## **Application: SSI 7485**

I write regarding the proposed modification to M4-M5 Link, Mod 2 The Crescent overpass and changes to pedestrian infrastructure in North Annandale, Rozelle and Rozelle Bay Foreshore area.

Figure 4-2 Pedestrian and cyclist bridge infrastructure options

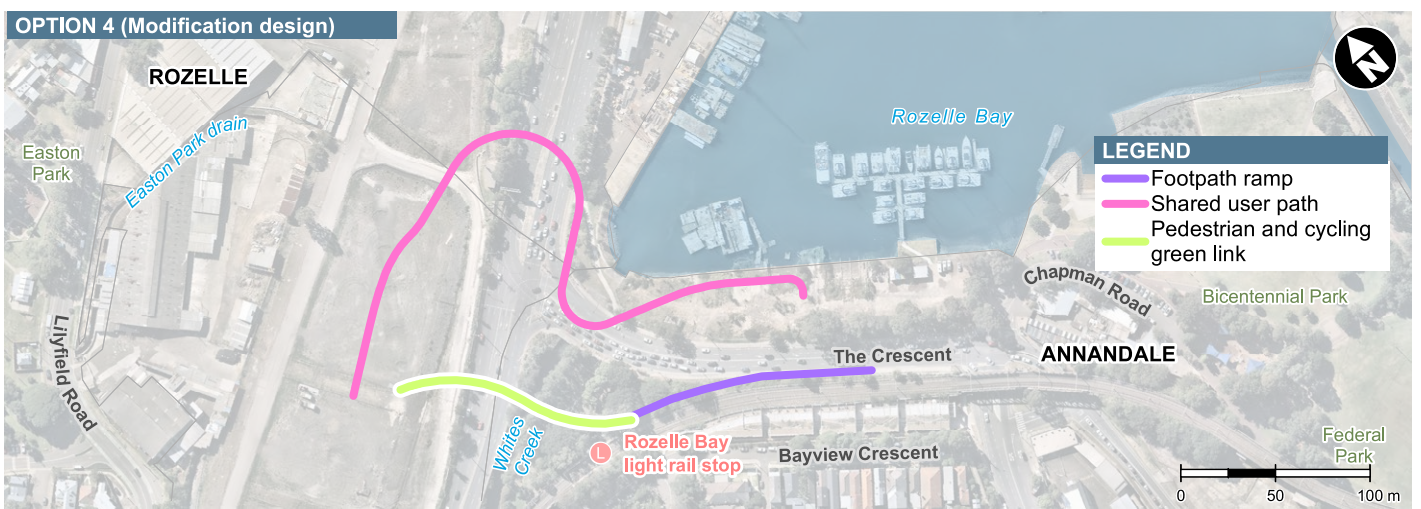
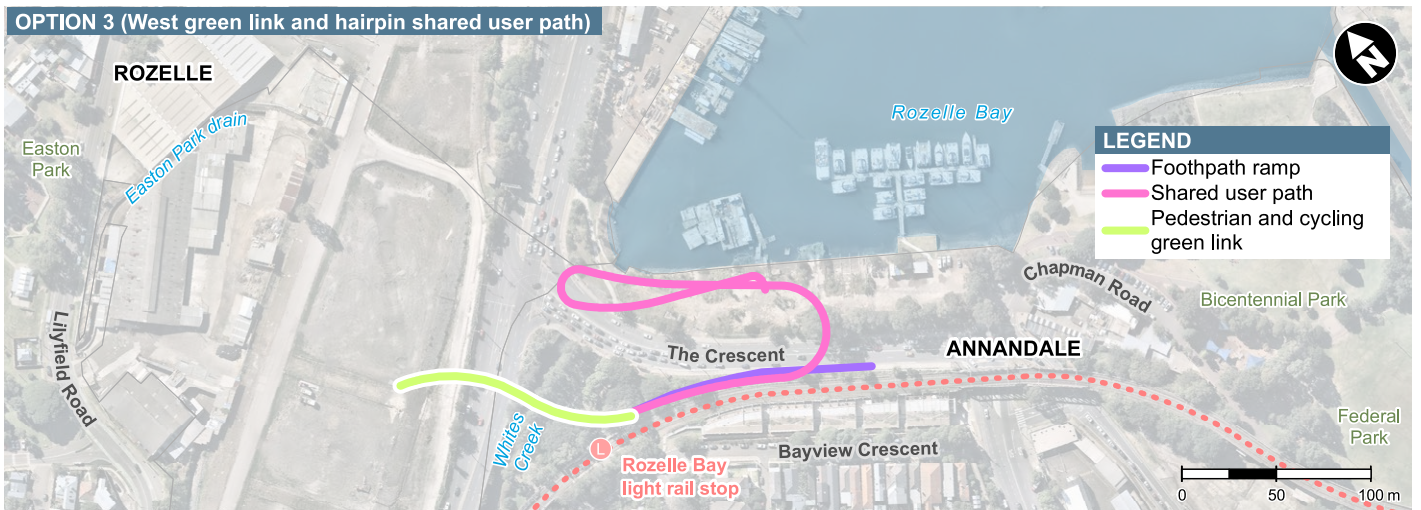
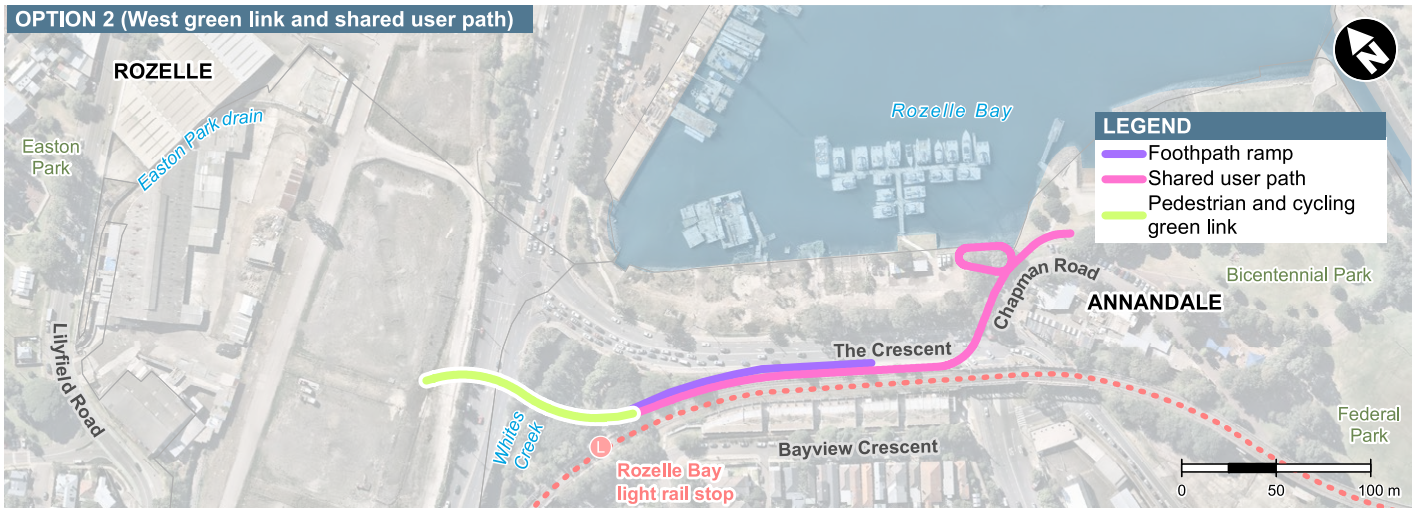
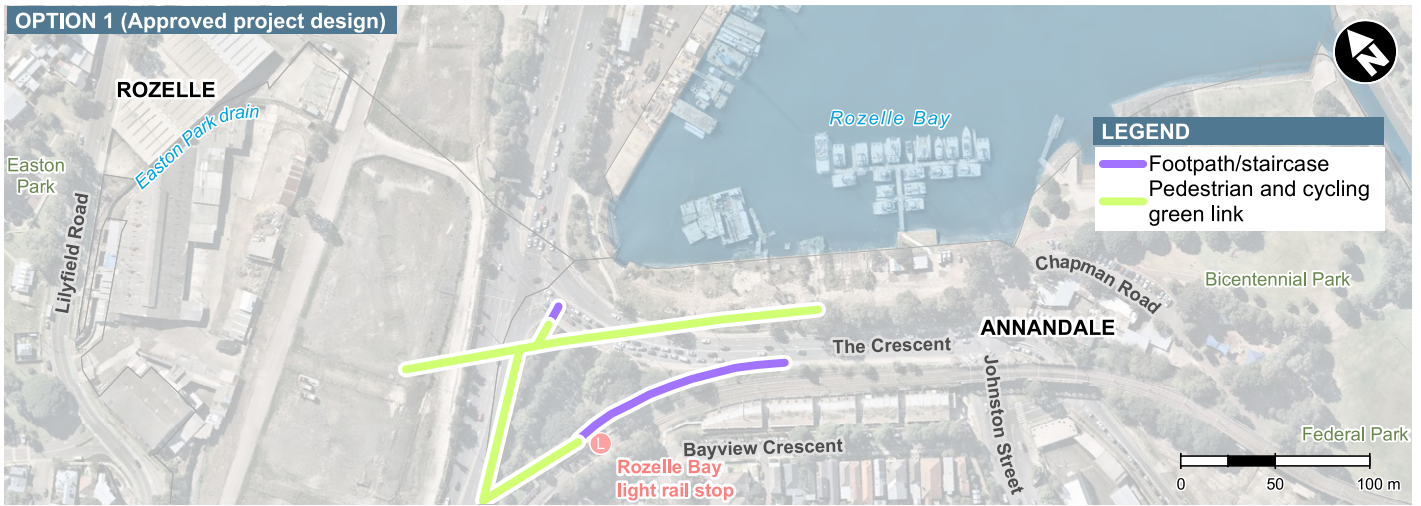
- **Enhance green links** The concept reactivates closed-off land through new green spaces and links. These links strategically establish a new green “interaction” connecting a series of significant yet fragmented [future and existing] green spaces in and around White Bay, Rozelle Bay, Rozelle, Balmain, Glebe and Annandale. **MOD 2 removes direct access**

- **Revitalise streets for equality of mobility** New public spaces and much-needed universally accessible links establish entirely new “public streets” and enhance the surrounding neighbourhood. **If, like me, you’ve pushed a heavy pram up long, steep ramps, looked after two kids on scooters on their way to the park or volunteered to supervise 60 school kids on their way to the park MOD2 is NOT an enhancement**

- Reinstatement of the GreenLink connecting communities and green open space from Rozelle to Bicentennial Park

Figure 4-4 Elevation: Indicative view of The Crescent overpass

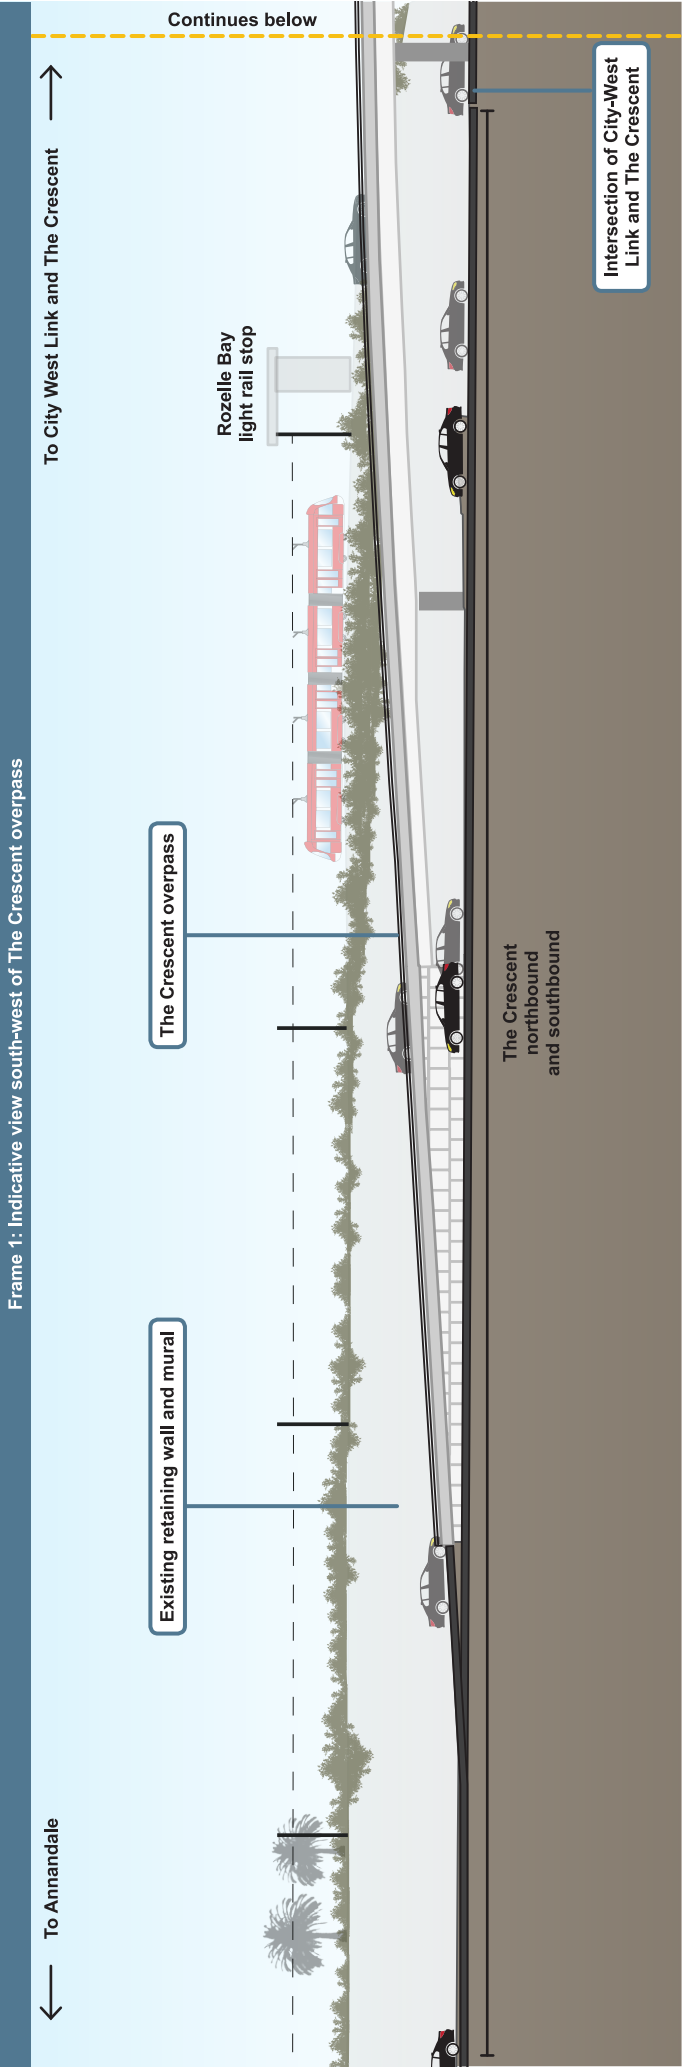
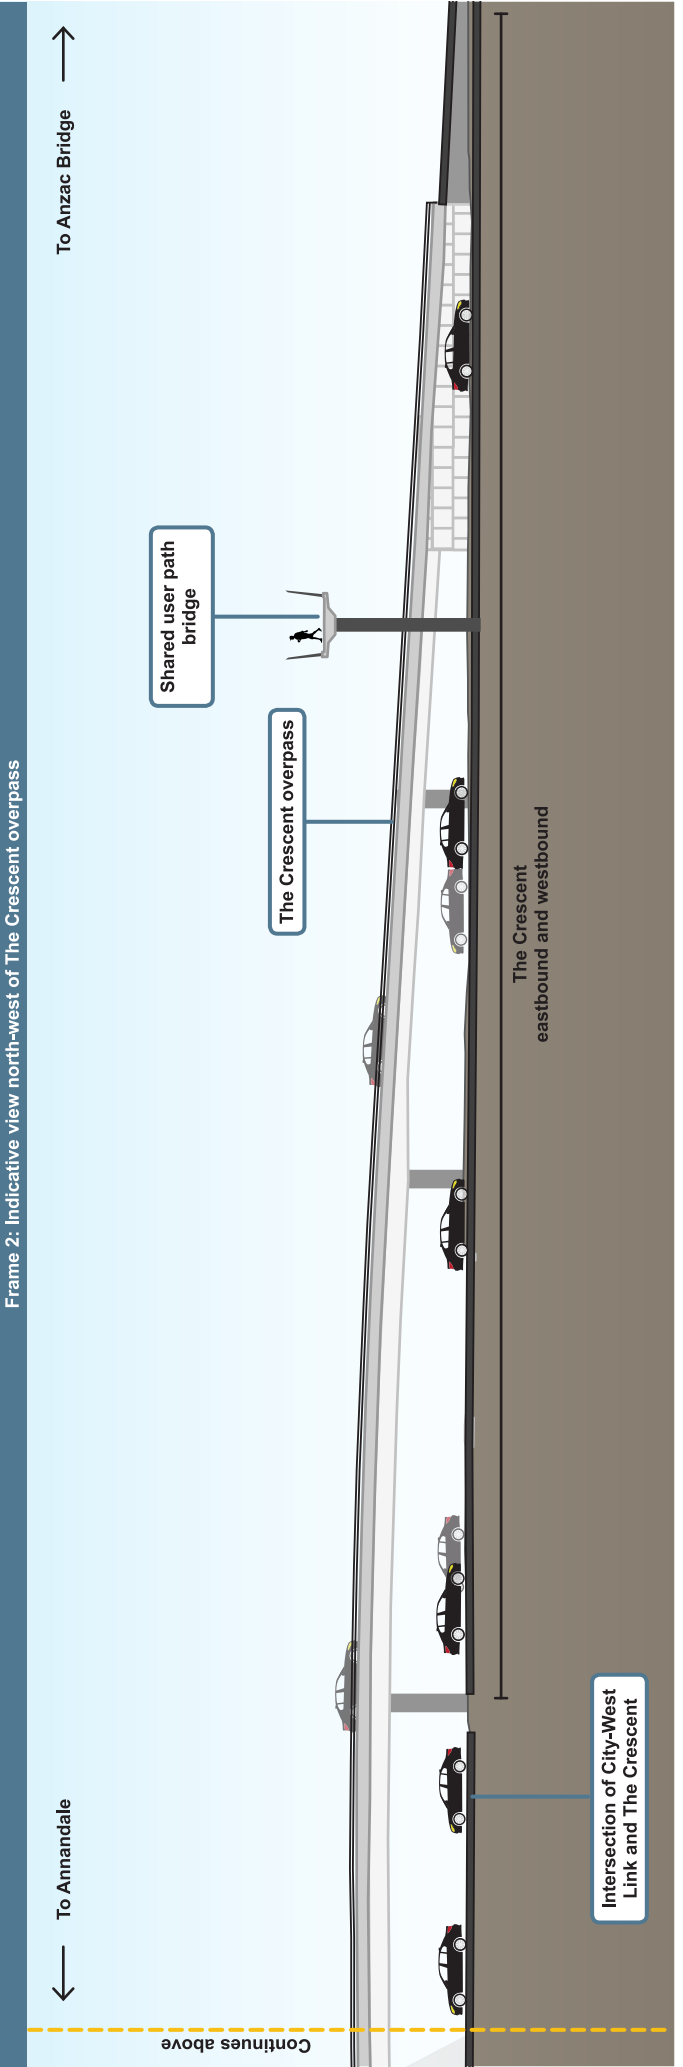
- The significantly reduced safety and increased risk for pedestrians and cyclists with removed access over The Crescent to Bicentennial Park and the increased traffic along Johnson Street.
- Being required to cross five sets of pedestrian lights at The Crescent as my option to reach the foreshore from Annandale or from Rozelle Bay light rail stop.
- Removal of direct active links to the foreshore, cutting the community off from the area and the proposed revitalisation of the entire Bays Precinct, including linking the Light Rail and Bus stops to a Ferry wharf and Metro station.
- Urban and landscape design that is being built before a finalised Masterplan for the area.
- Traffic changes that limit movements around the suburb and create further congestion in the local streets of Annandale, Forest Lodge, Glebe, Lilyfield and Rozelle with no planning to deal with these.

- **Respond to the local character** Respecting and maintaining the unique heritage, industrial character and topography of the Rozelle Rail Yards through interpretation. **A massive concrete overpass obstructing a historically significant local mural and concrete plaza — really?**

- Relocate and design pedestrian and cyclist connections that are continuous, safe and direct.
- Design the modification infrastructure and active links in response to the character of the suburbs, the location of the foreshore and it's potential future development.
- Provide pedestrian and cyclist paths that maximise people safety and do not force them onto busier streets, unsafe concrete plazas and caged walkways.
- Integrate active and direct connections to all active transport – including the future Metro West and Foreshore Ferry Wharf
